Subject: RE: Yapton Metal Company - refs Y/42/19/DOC and Y/61/19/PL

With regards to your points I can confirm that our stance remains unchanged. You will need to supply winter groundwater testing through to March. I reassure you we are not asking any more of your applicant than any other of the same size in the district, it is for this reason that I cannot recommend or accept reduced testing (to December), as others will want the same treatment.

TYPICAL SECTION THROUGH PERMEABLE
COURTYARDS AND PRIVATE DRIVEWAYS
(WITH CONSTRUCTION TRAFFIC / HGV's)

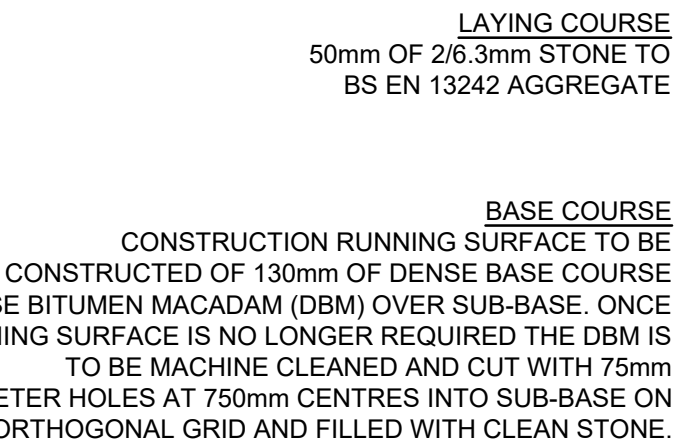
Further winter infiltration testing will be required, at the depth of your proposed permeable paving, as ground conditions in July would be expected to be more permeable. Whilst I am confident you will be able to find an infiltrating solution within the confines of the site I am unable to approve discharge of conditions until you can prove your design meets our requirements with both calculations and testing.
